Date: 29 January 2025  
Your Ref: EN010125/IP No. 20050058  
Our Ref: 17996

**IP NO. 20050058 – WRITTEN REPRESENTATIONS ON BEHALF OF NET ZERO NORTH SEA STORAGE LIMITED**

**EN010125 – APPLICATION BY RWE RENEWABLES UK DOGGER BANK SOUTH (WEST) LIMITED & RWE RENEWABLES UK DOGGER BANK SOUTH (EAST) LIMITED FOR AN ORDER GRANTING DEVELOPMENT CONSENT FOR THE DOGGER BANK SOUTH OFFSHORE WIND FARMS**

- Offshore Order Limits
- Offshore Order Limits Node Point
- Sheet Boundary

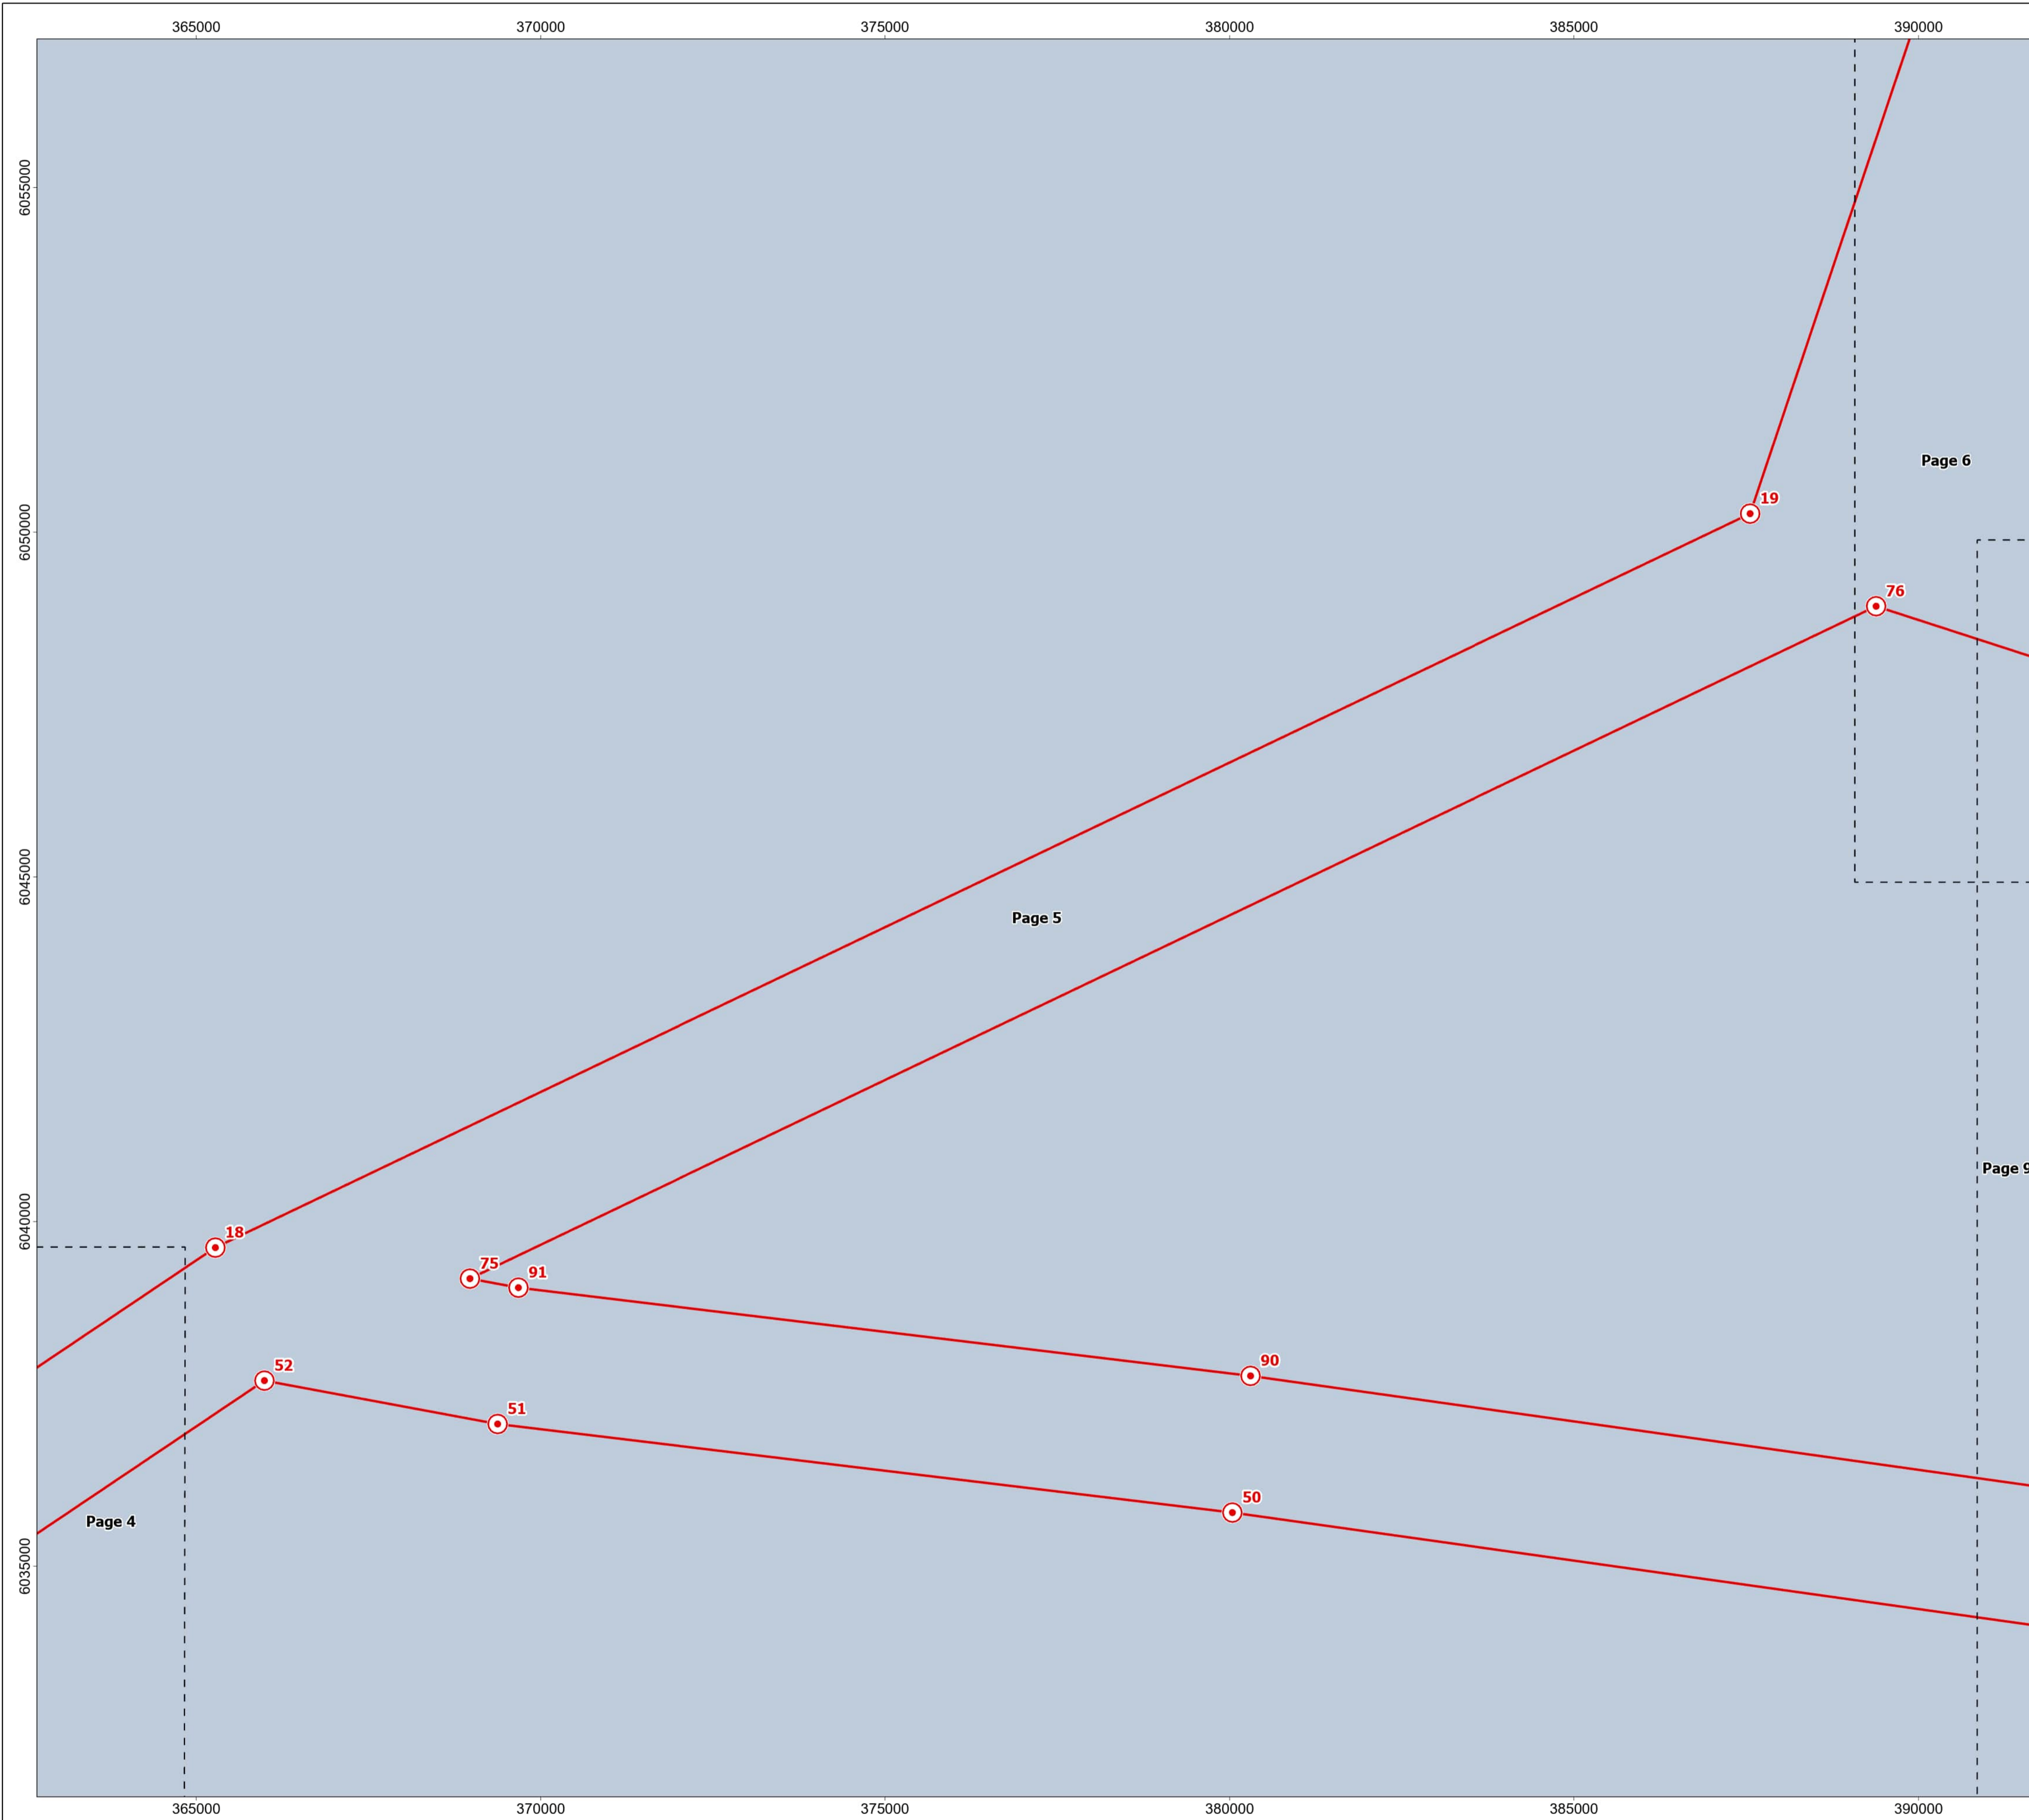
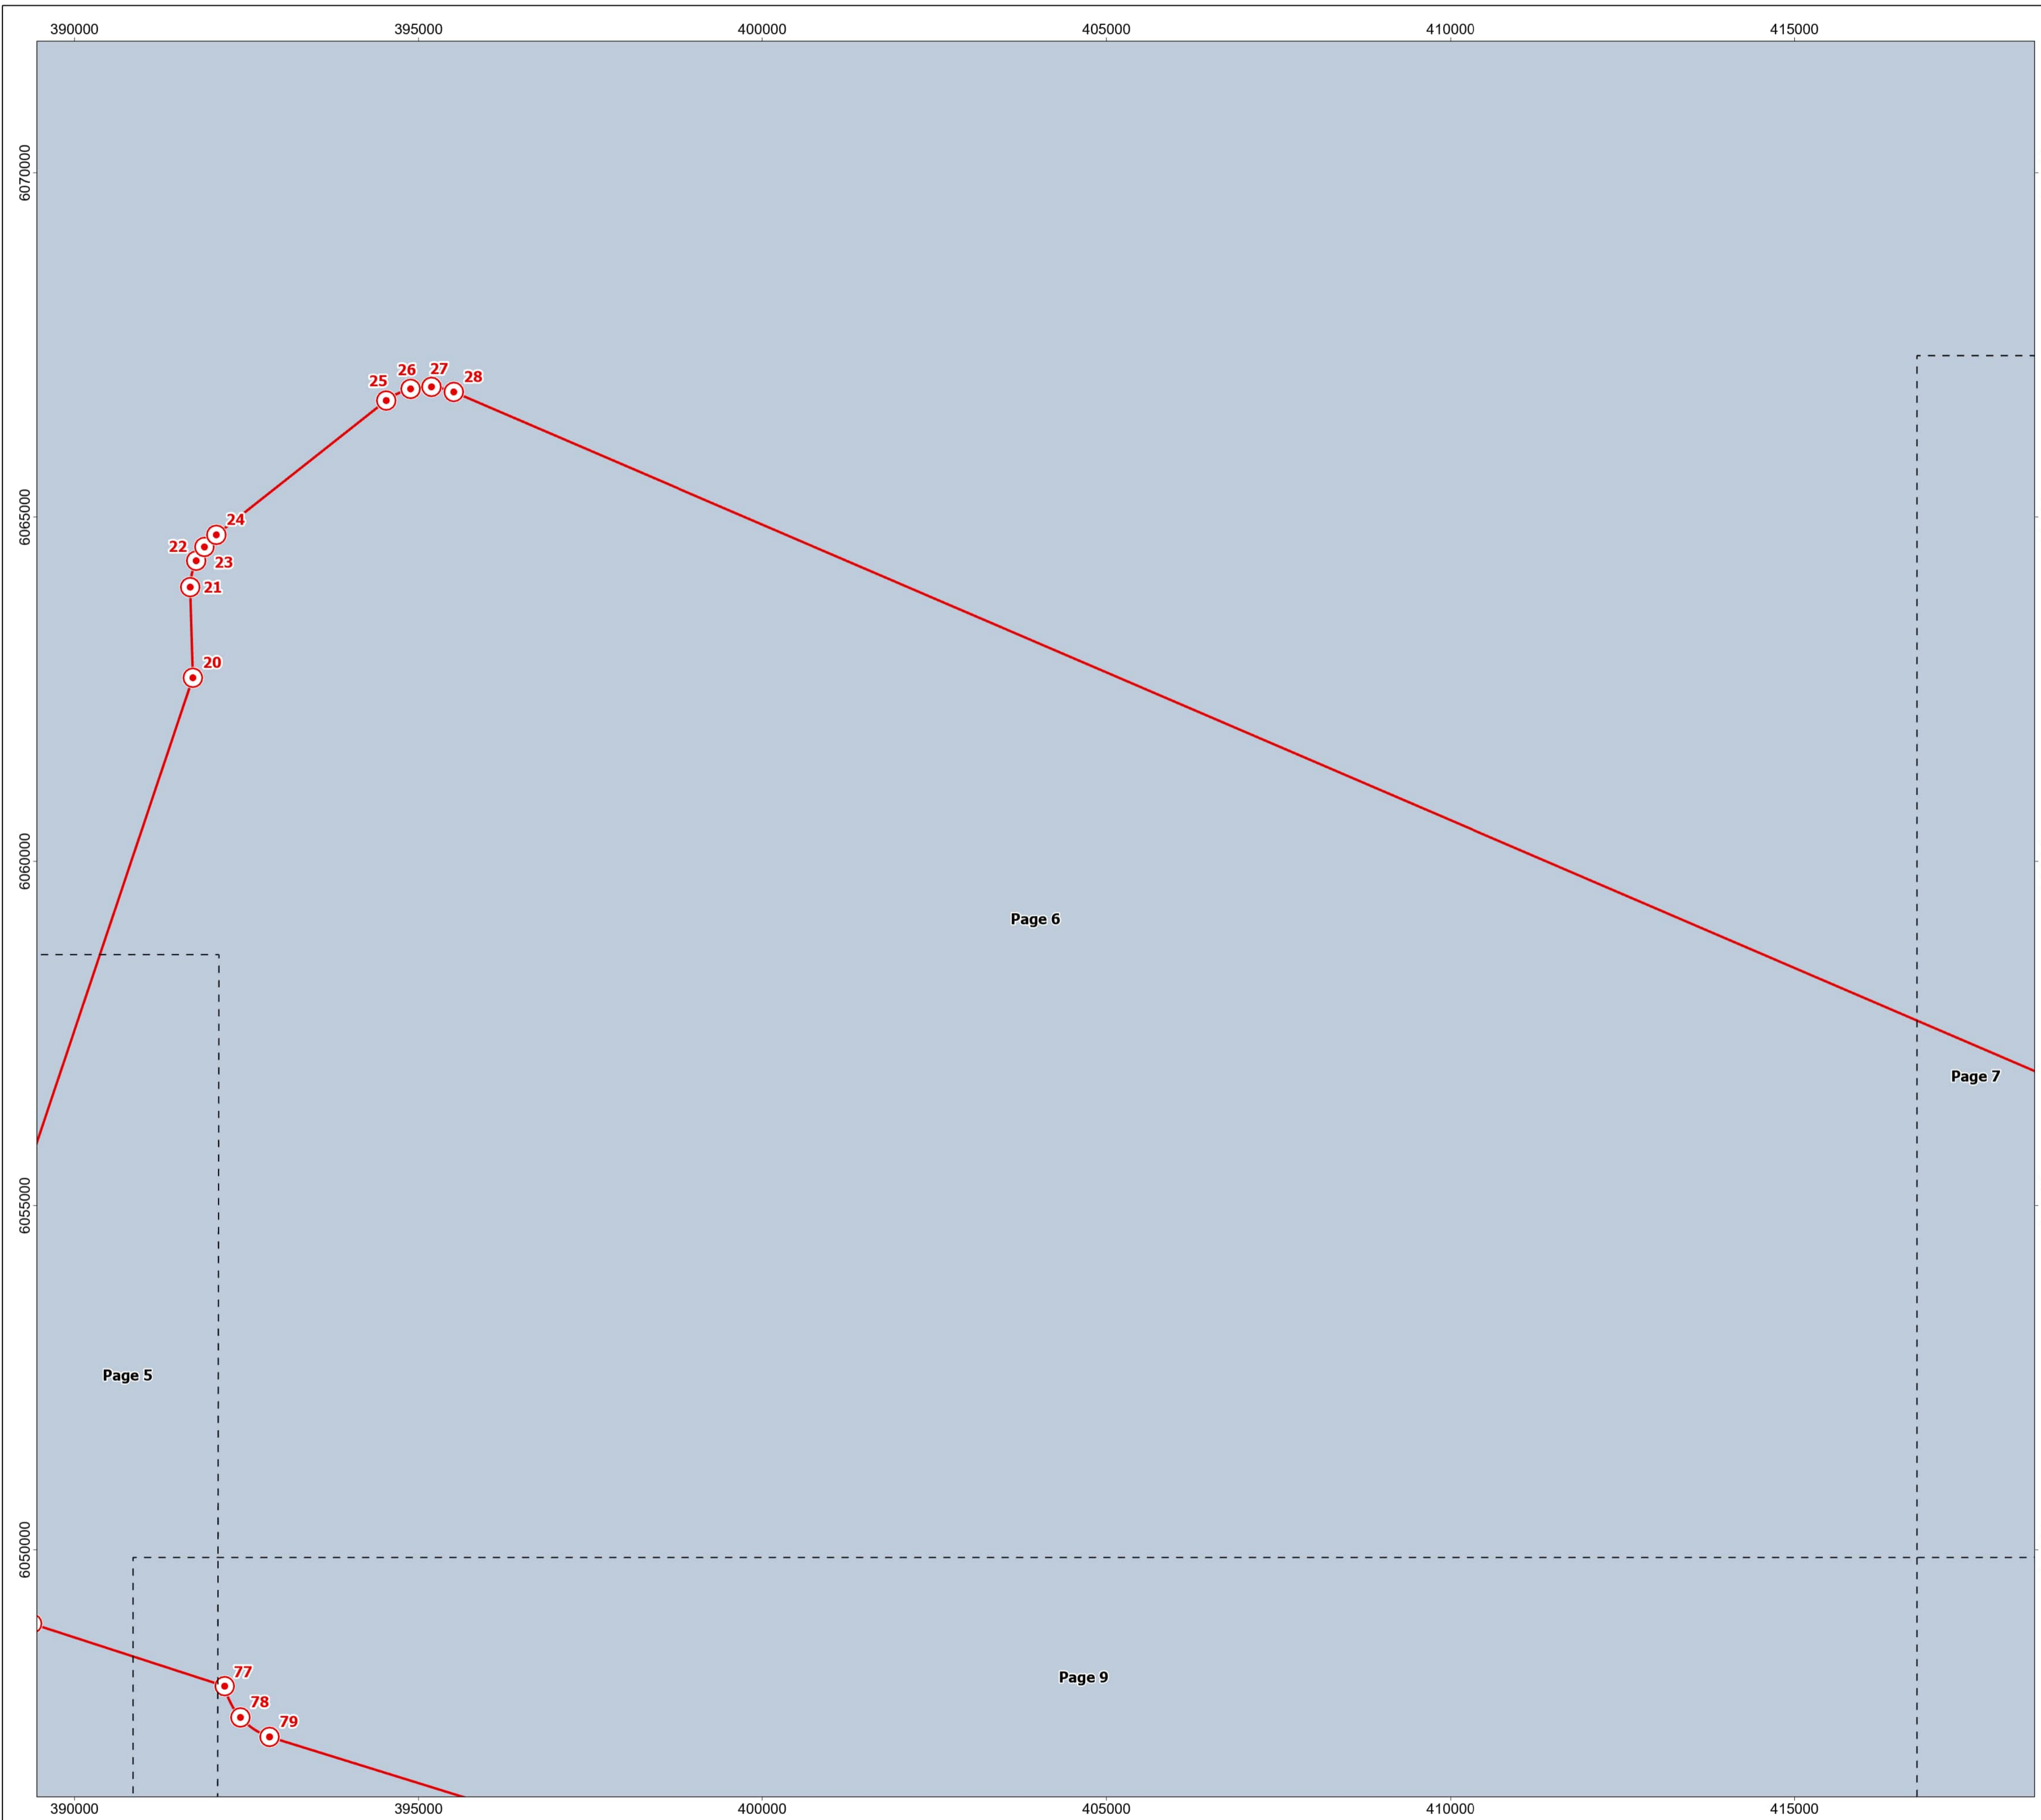
The Land and Works Plans that form part of the Application indicate that the electrical cable corridor for the Proposed Development will cross the Teesside pipeline. In addition, the southern routing of the electrical cable corridor will cross the CS025 Storage Licence area where NEP is developing a further carbon dioxide store.

Having reviewed a number of the key application documents, NSNZS is concerned as to the lack of detail within the Application on how the interactions of the electrical cable corridor with the Teesside pipeline and the CS025 carbon dioxide store will be managed and any impacts mitigated.

NZNSS needs to see further information as to the construction methods that RWE proposes to cross the Teesside pipeline and the carbon dioxide store and how construction and other impacts will be minimised and mitigated in order to ensure that it is satisfied that there will be no adverse effect on the NEP infrastructure and its operations.
